LOCAL IMPACT REPORT

Application by Boston Alternative Use Boston Projects for a Development Consent Order granting Development Consent for The Boston Alternative Energy Facility at Riverside Industrial Estate, Boston – EN010095

Produced by Lincolnshire County Council (LCC)

October 2021

BOSTON ALTERNATIVE ENERGY FACILITY DEVELOPMENT CONSENT ORDER
 Regulation 5(2)(k) - Access and Rights of Way Plan
 BOSTON BOROUGH COUNCIL
 Sheet 1 of 1

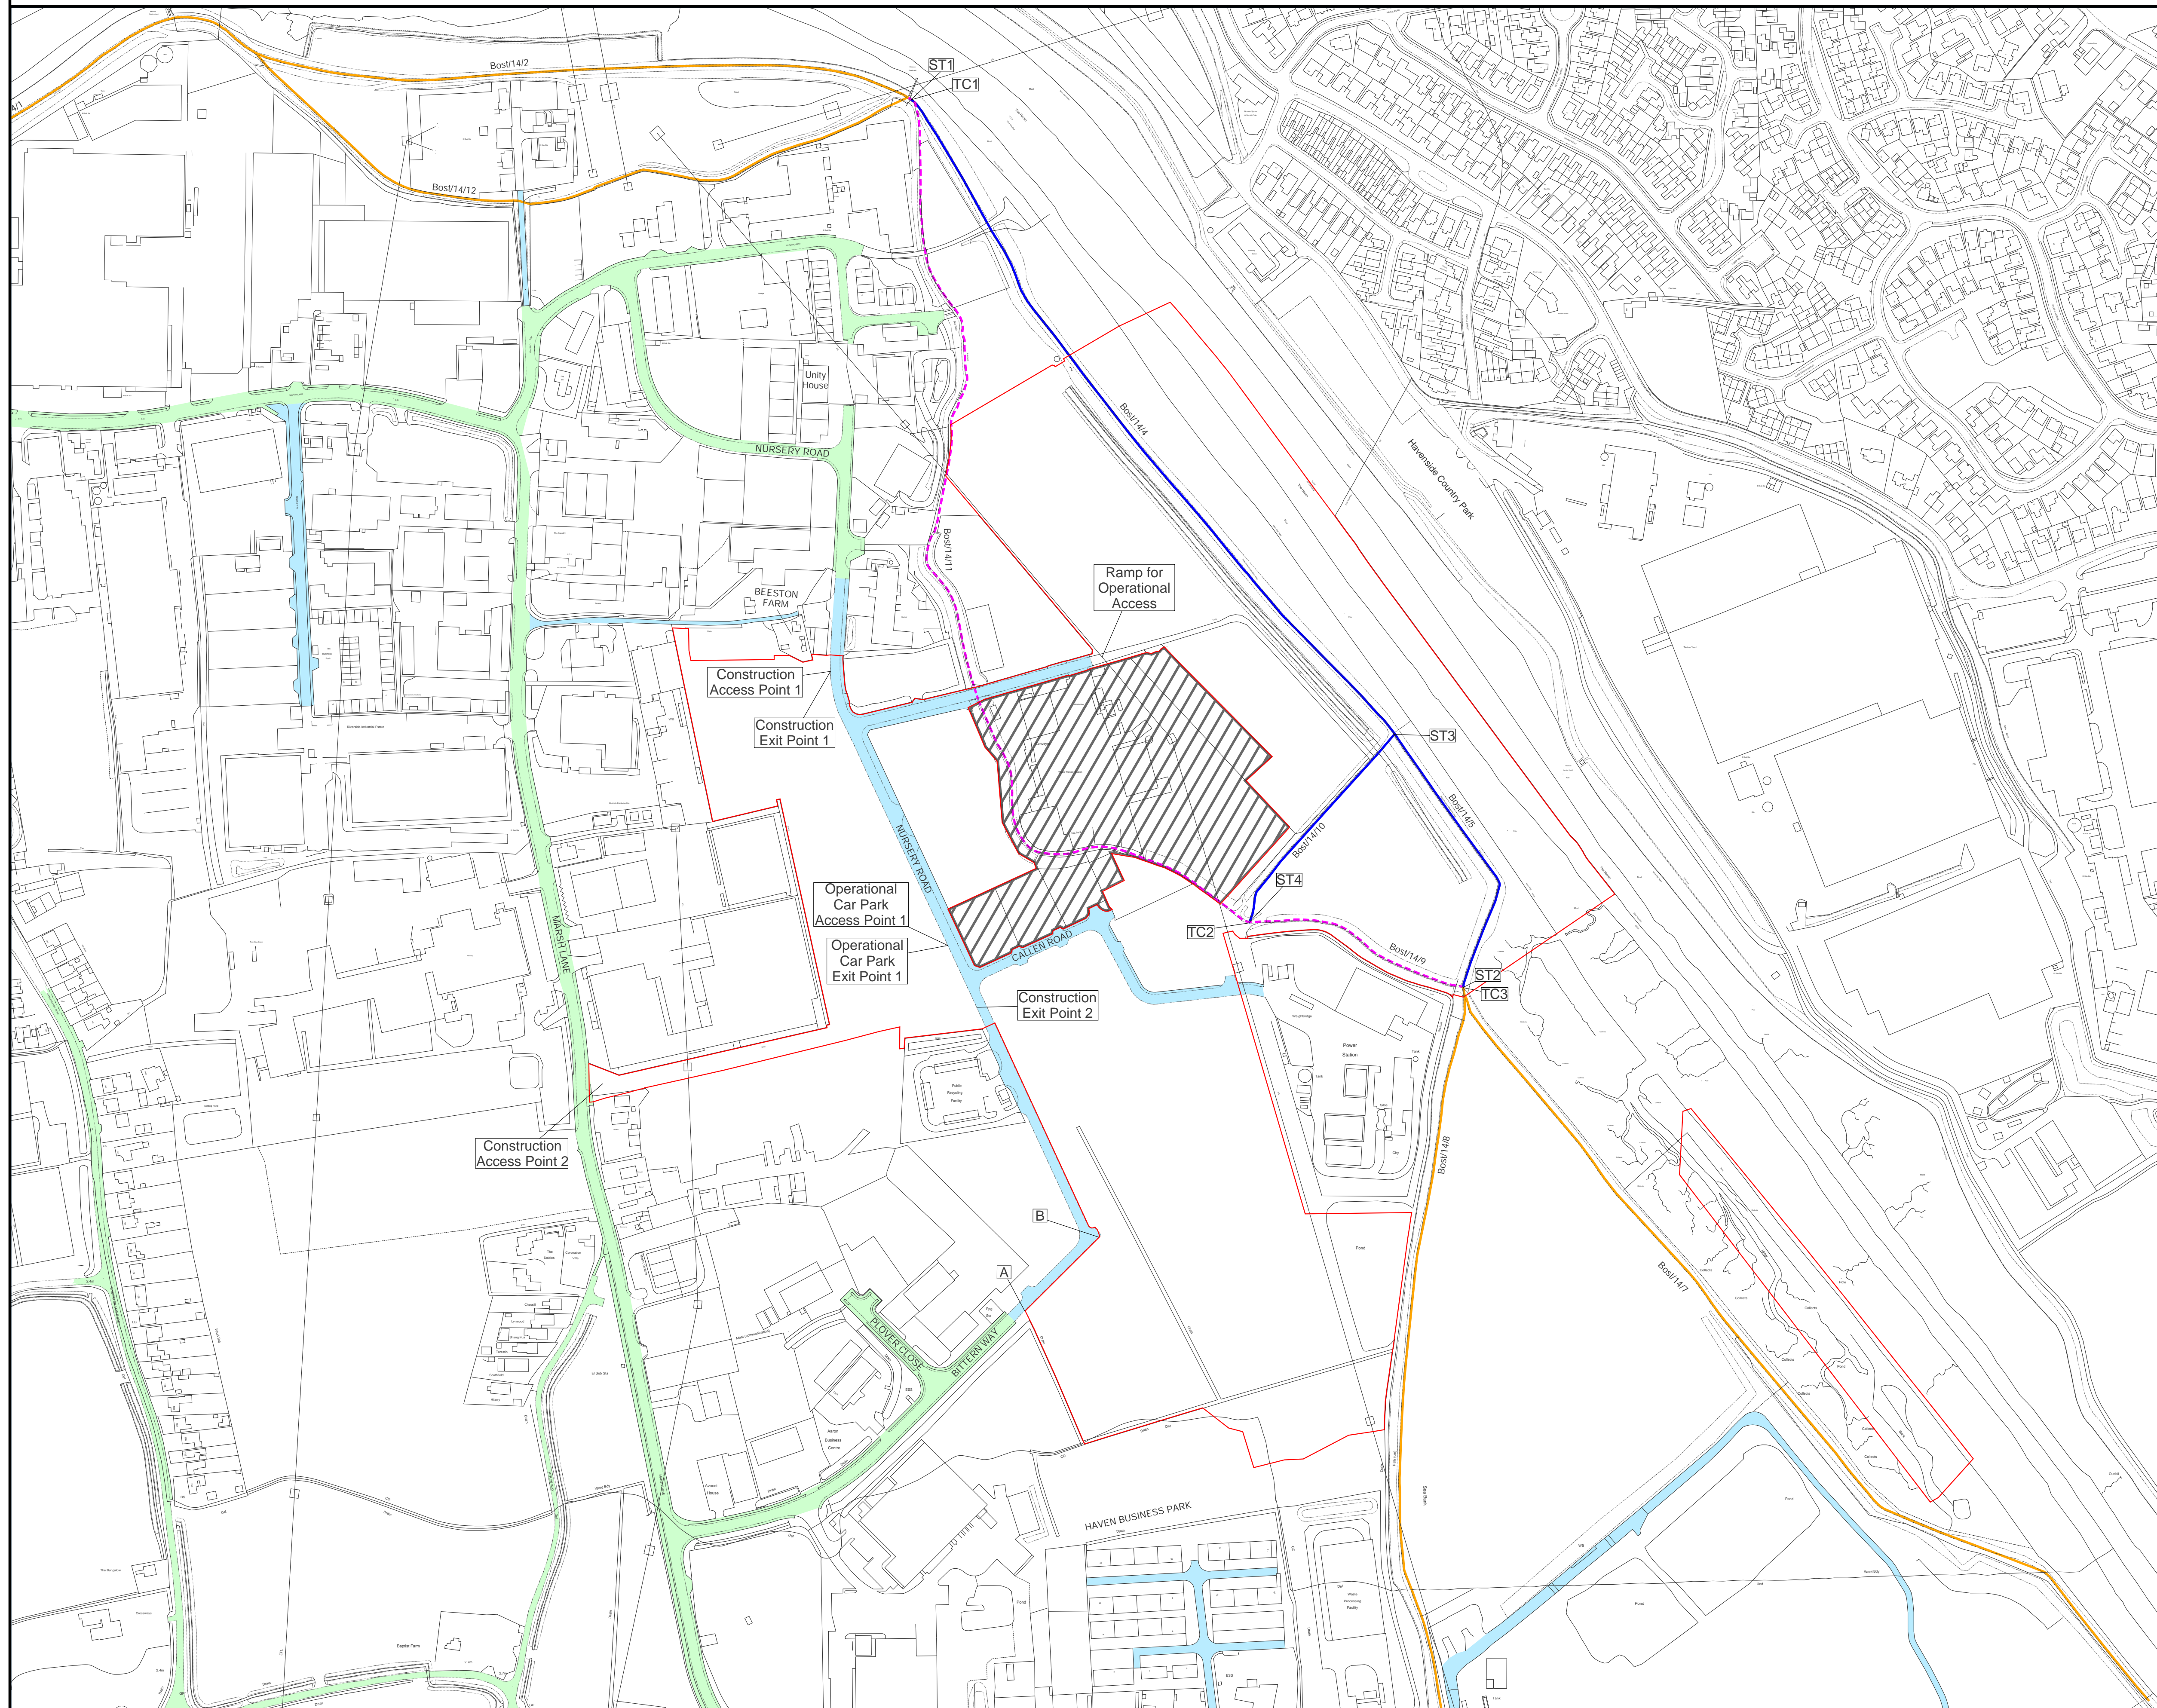
- 6.3.2 There is a net loss of approximately 1 km of public rights of way across the scheme with no indication of any specific mitigation to offset this loss. It is suggested that it may be a prudent opportunity to undertake improving the rights of way from London Road to Lealand Way (Boston PF14/1 and 14/2) for them to be created as cycleway /footway and appropriately surfaced to provide safer commuting access to the Industrial Estate and recreation purposes which could be secured by an appropriately worded requirement or Planning Obligation.

- 6.3.3 Clearly there will be need to appropriately programme the temporary closure orders and subsequently required extensions for the works proposed that will affect the old sea bank including the installation of a temporary footbridge to keep walkers away from construction traffic.
